**WELWYN HATFIELD BOROUGH COUNCIL
ASSISTANT DIRECTOR (PLANNING)**

Application No: 6/2023/0900/LAWP
Location: Sandpit Lodge Bedwell Avenue Hatfield AL9 6HN
Proposal: Certificate of lawfulness for a proposed single-storey rear extension, single-storey side extension and single-storey basement underneath the original dwellinghouse and erection of single-storey outbuilding
Officer: Mrs Kerrie Charles

Recommendation: Refused

A Proposed Basement Plan
PD12 1:100

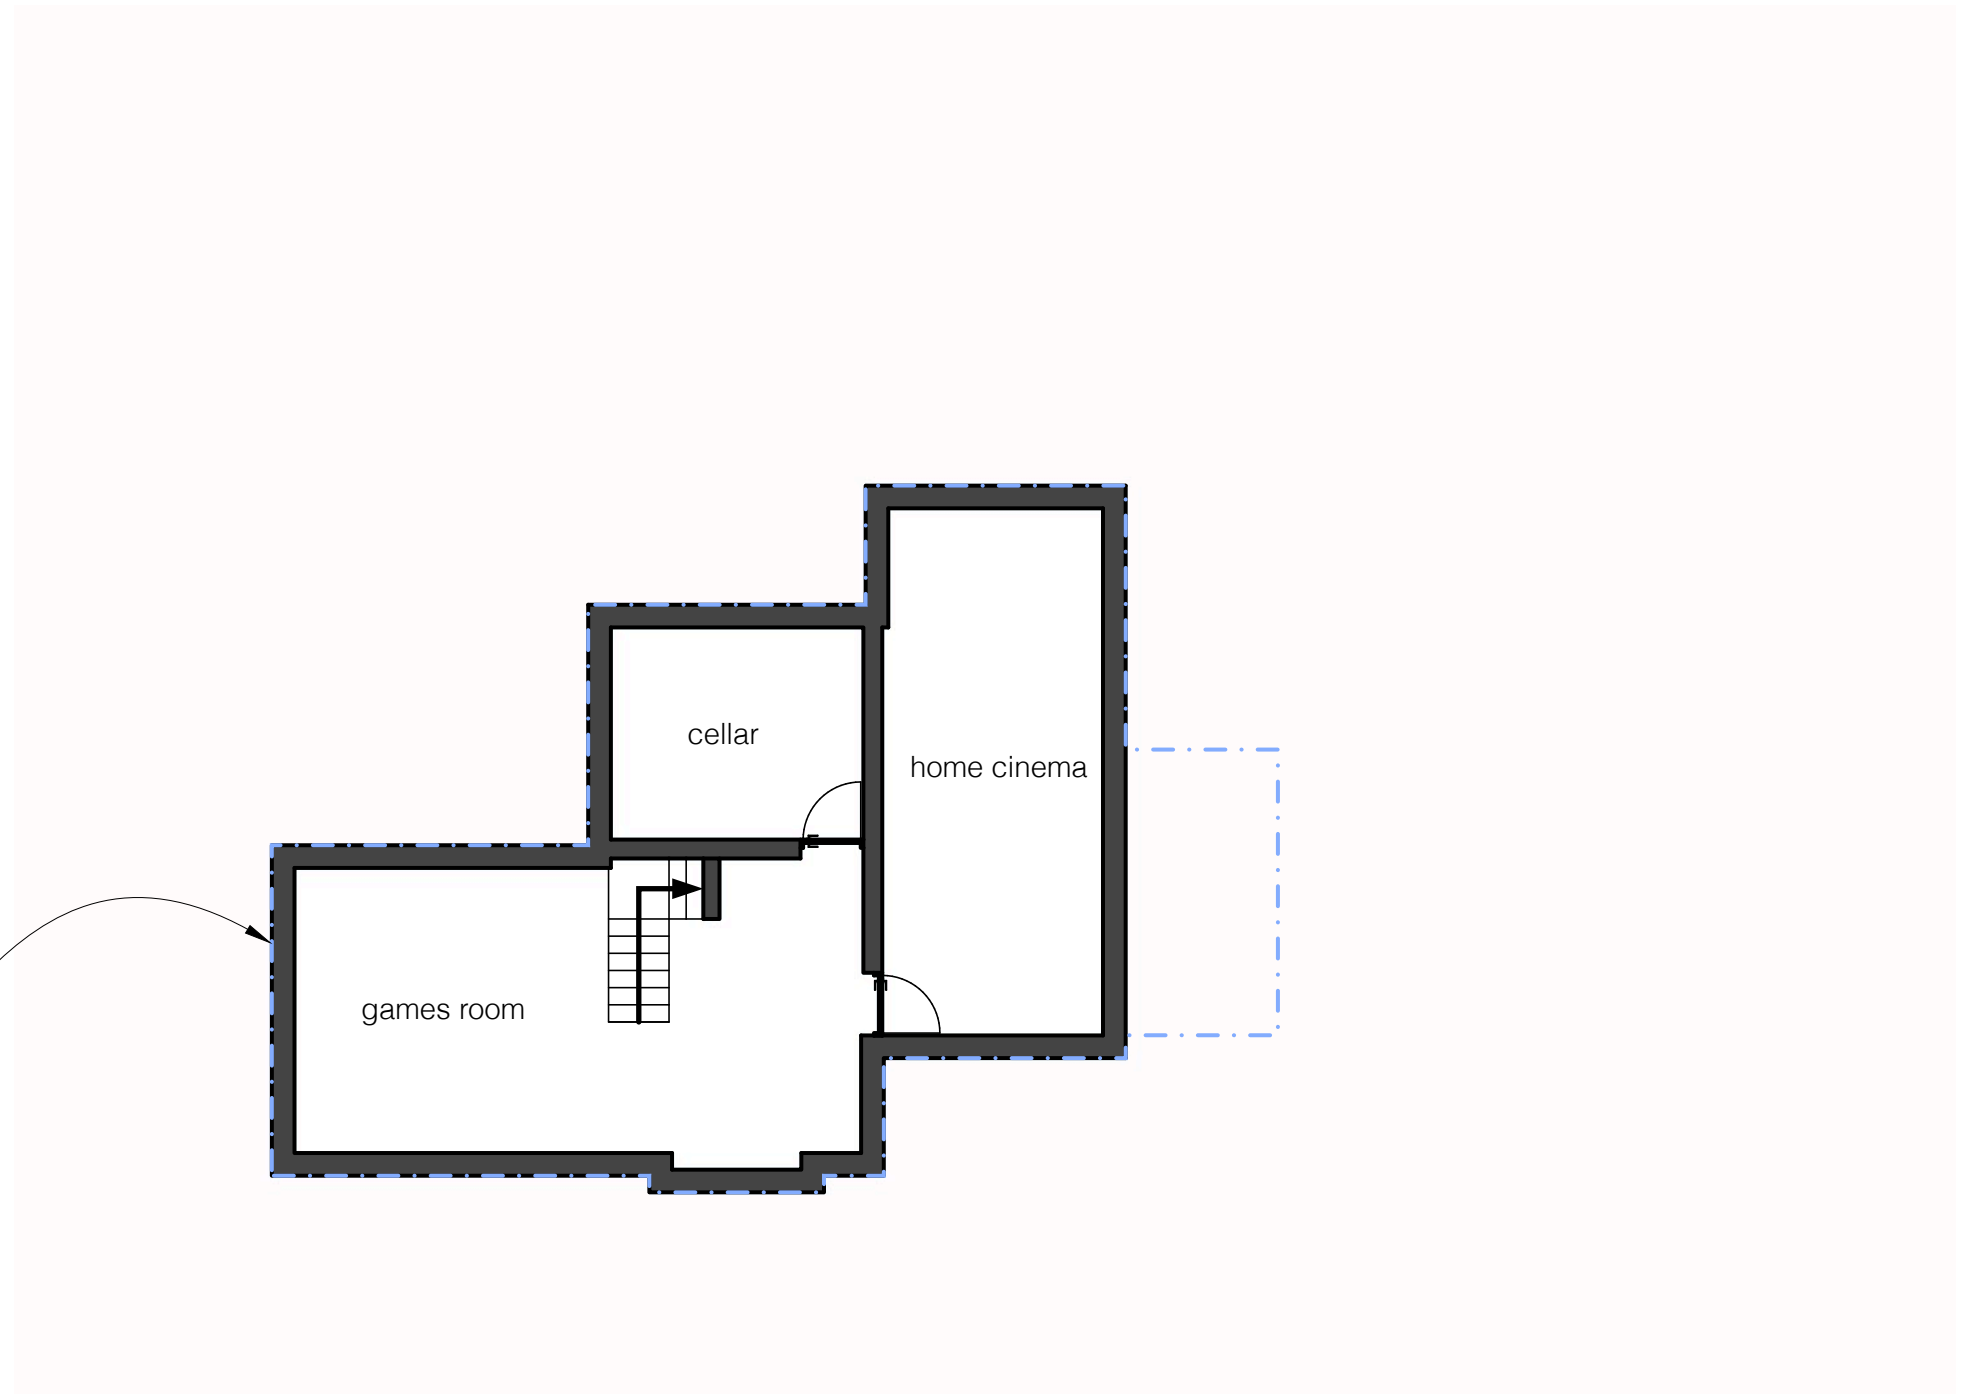
this could possibly adhere to Schedule 2 Part 1 Class A of the GDPO. However, the lack of a basement would result in: 1) the enlargement, improvement and alteration aspect as well as 2) the engineering aspect of excavating a space and supporting a house as one is indivisible from the other. As such this separate aspect would require planning permission.

The proposed basement is contrary to Schedule 2, Part 1, Class A of the Town and Country Planning (General Permitted Development) (England) Order 2015 (as amended). Planning Permission is therefore required.

A Floor Plan 1:100

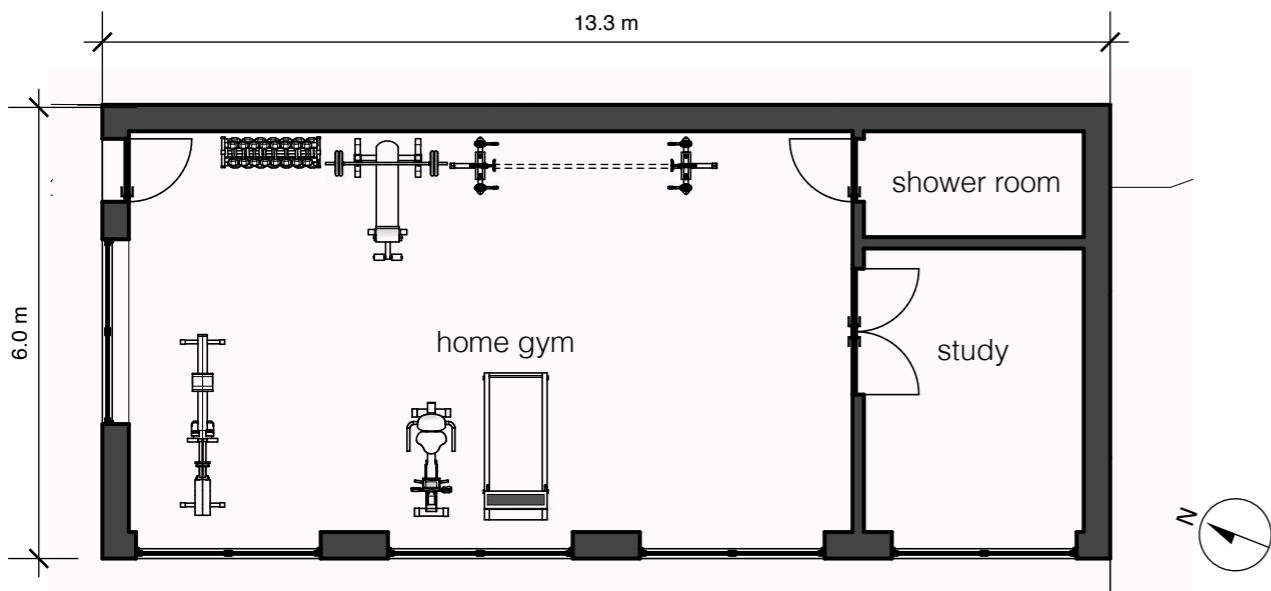
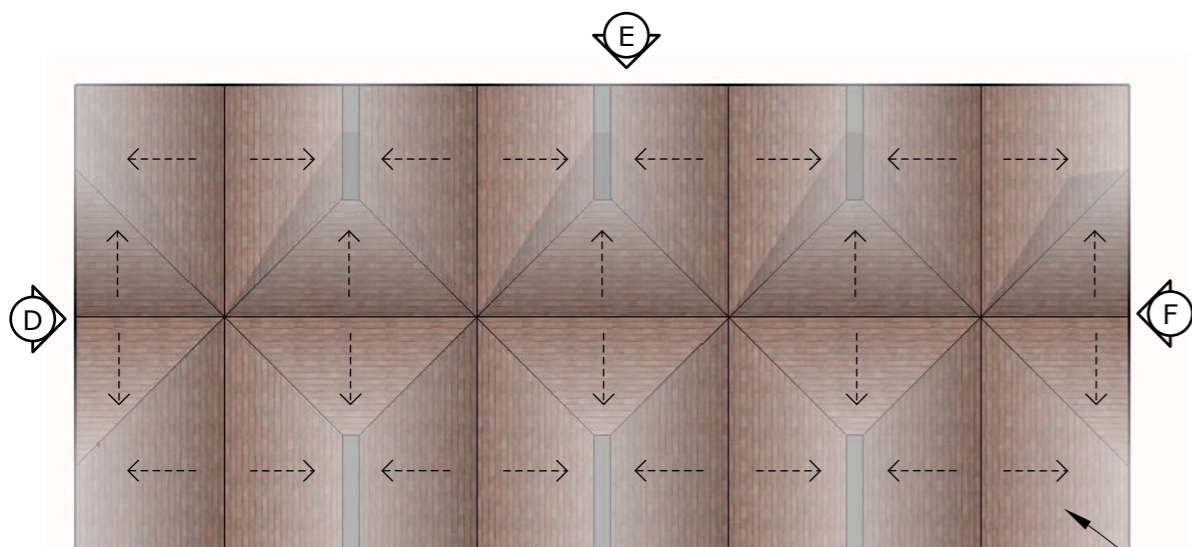
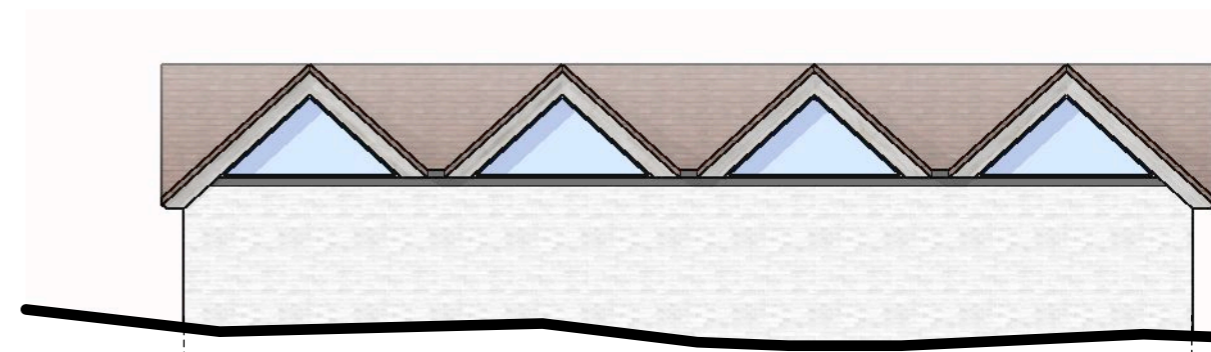
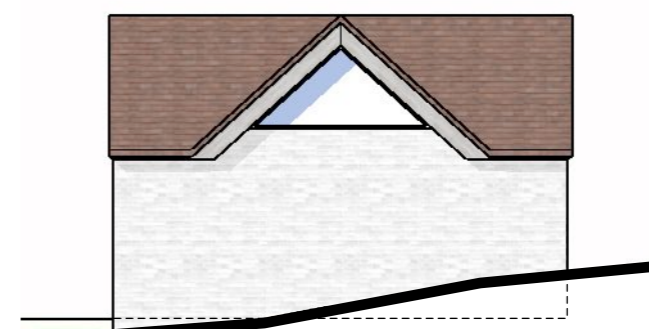
In regards to the proposed outbuilding. The host dwelling has a total footprint of approx. 72.9sqm (original) 80sqm (with conservatory), the proposed outbuilding would have a footprint of approx.80sqm. Consequently, it is considered the proposed outbuilding exceeds what may be reasonably considered as incidental to the enjoyment of the host dwelling. The proposed building would have a footprint greater than that of the original dwelling and would be of the same footprint of the existing dwelling (with conservatory).

Although the activities designated on the proposed plans of the proposed outbuilding fall into the categories that individually may be acceptable as incidental to the enjoyment of the dwellinghouse, taken together they occupy an unreasonable amount of space. In the matter of fact and degree the proposal would not come within the terms of Schedule 2 Part 1 Class E of the GPDO (as amended).

As such, it is considered that due to the total footprint to be created by the proposed outbuilding it would not be deemed incidental to the main dwelling, especially not in comparison to the original size of the dwelling. Therefore, such a proposal is not considered to be incidental to the enjoyment of the dwellinghouse This element of the proposal would not be incidental to the enjoyment of the dwelling contrary to Part 1 Class E (a) of the GPDO.

The proposed outbuilding is not considered to be incidental to the enjoyment of the dwellinghouse This element of the proposal would not be incidental to the enjoyment of the dwelling contrary to Part 1 Class E (a) of the GPDO, therefore Planning Permission will be required.
